Re: Zero Canal Plaza Development
Level II Site Plan Application – Response to Comments

Review Memos from Caitlin Cameron, dated 8/3/16

Engineering Review memo from Stephen Bushey, dated August 1, 2016

1 TREE PLANTING - PLAZA
 1/2"=1'-0"

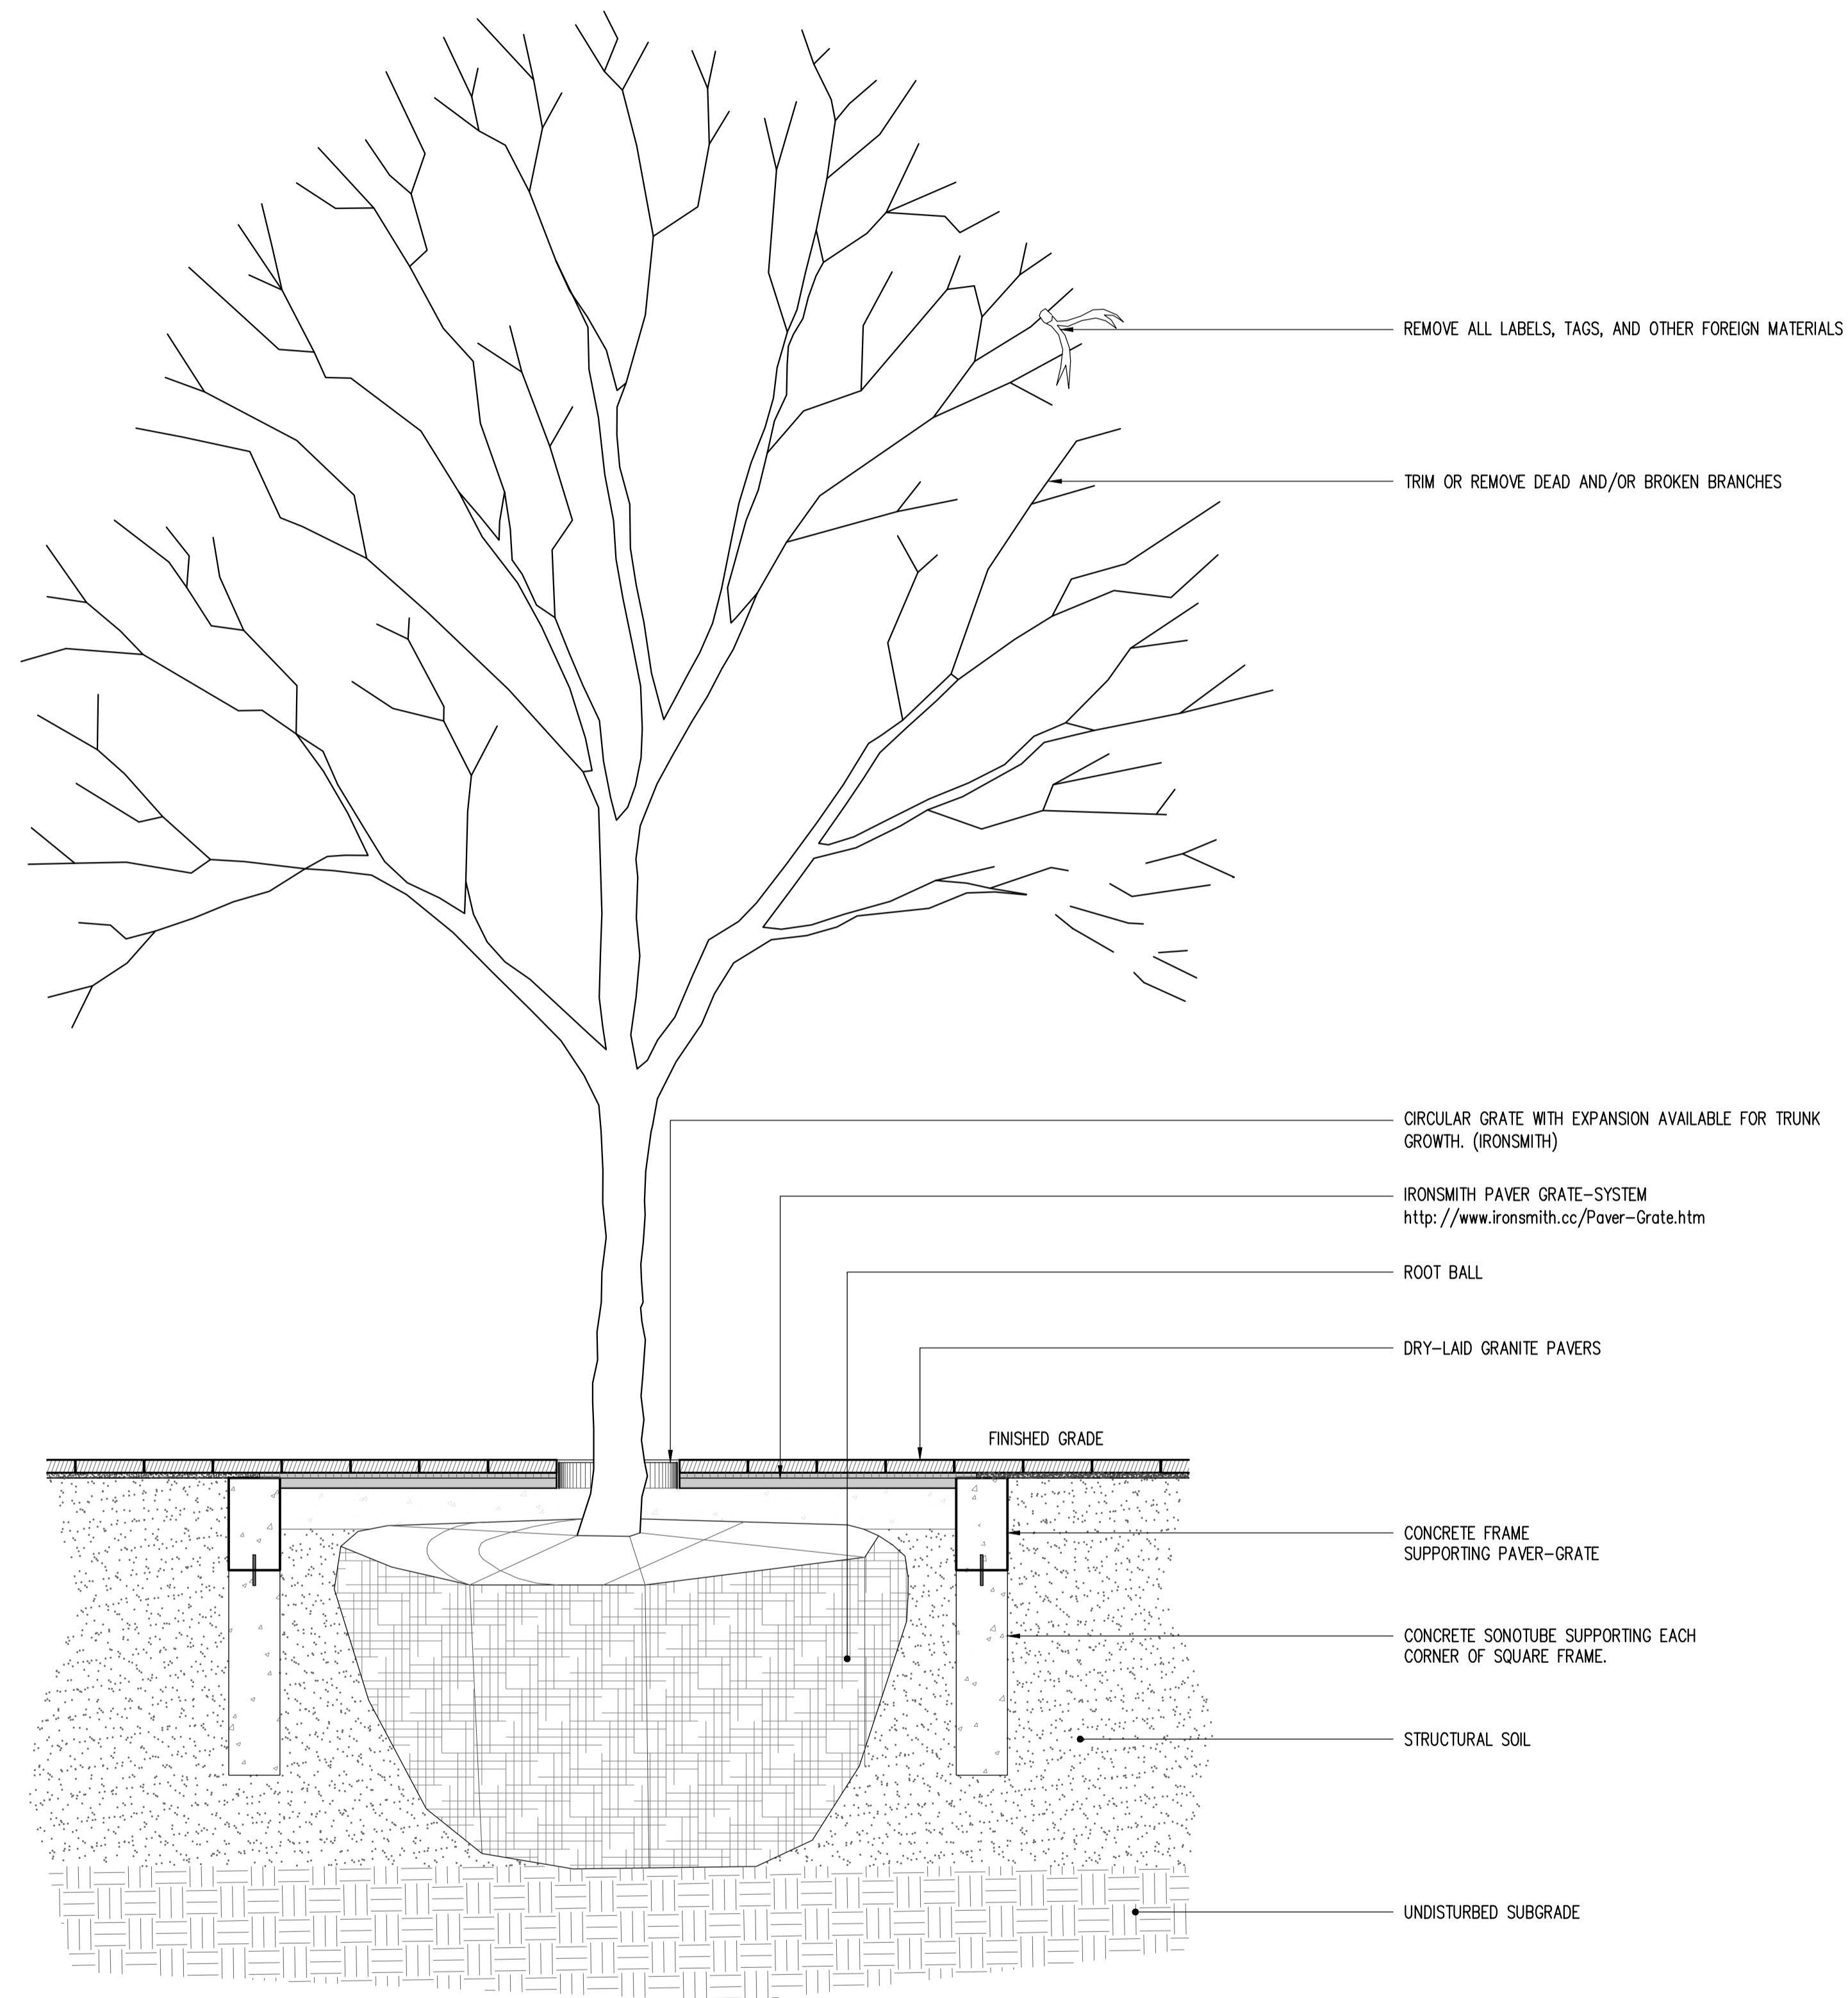
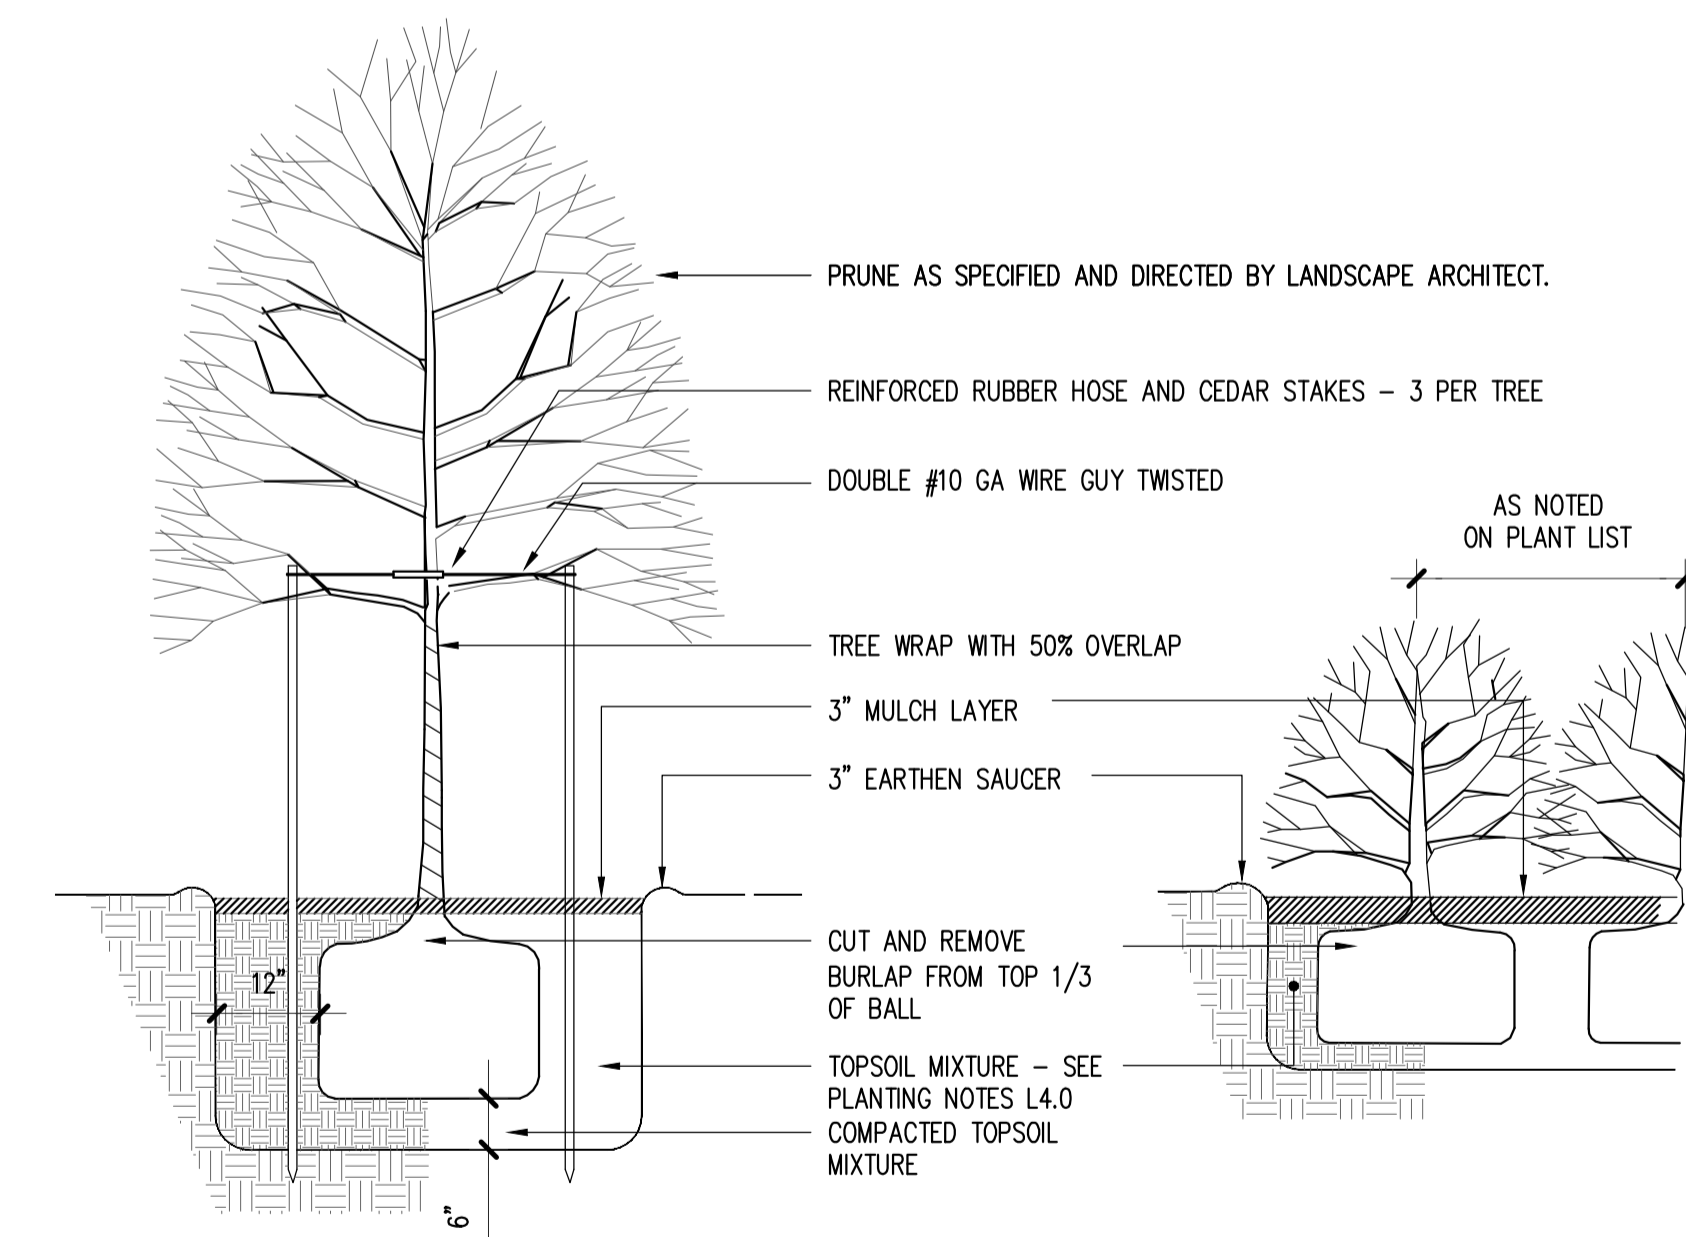
- *Comments submitted by Jeff Tarling/City Arborist*
 - *There is some concern about winter maintenance if no raised curb is to be provided around plaza trees – using magnesium chloride is preferred for salting to preserve the trees. The planting plan is approved with the condition that changes to the tree species or structural soil must be approved by the City Arborist.*

- Extra care will be taken when clearing snow around the trees, and temporary tree protection during winter months will be provided as required. Preference will be given to magnesium chloride during winter months. The tree species that was selected is commonly utilized as an urban street tree, and within the plaza space, it will see less impact (salting, sidewalk plowing,

street plowing) than typically experienced when the trees are installed within a sidewalk. While it is not anticipated that the tree species will change, any changes will be submitted for approval by the City Arborist.

**MASONRY PLUG DETAIL**  
N.T.S.

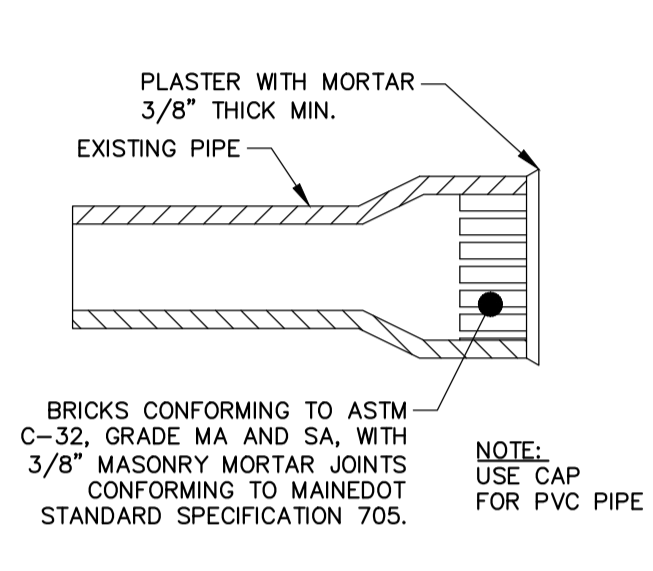
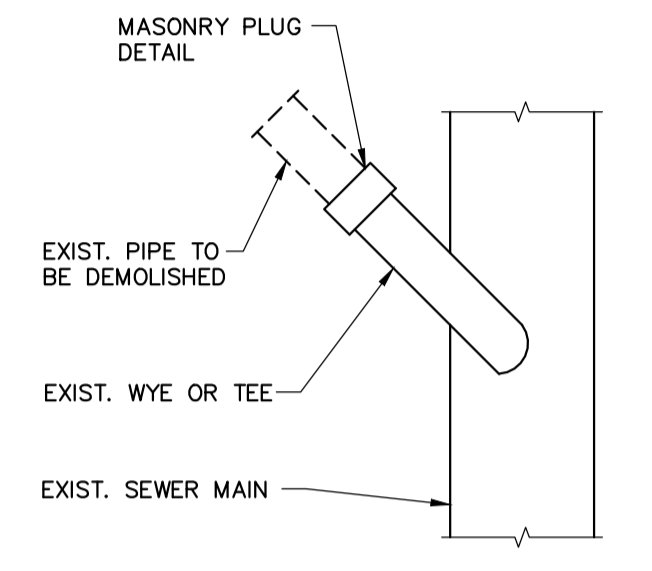
2. *The Public Works Department should weigh in on the abandonment of the 12” SD off the Middle Street arterial. The plan calls for the placement of flowable fill in the pipe and capping.*

The PWD may want a masonry infill on the pipe entry into the existing CB or some other form of permanent blockage.

The notes provided for the existing catch basin include the installation of a masonry plug as part of the demolition.
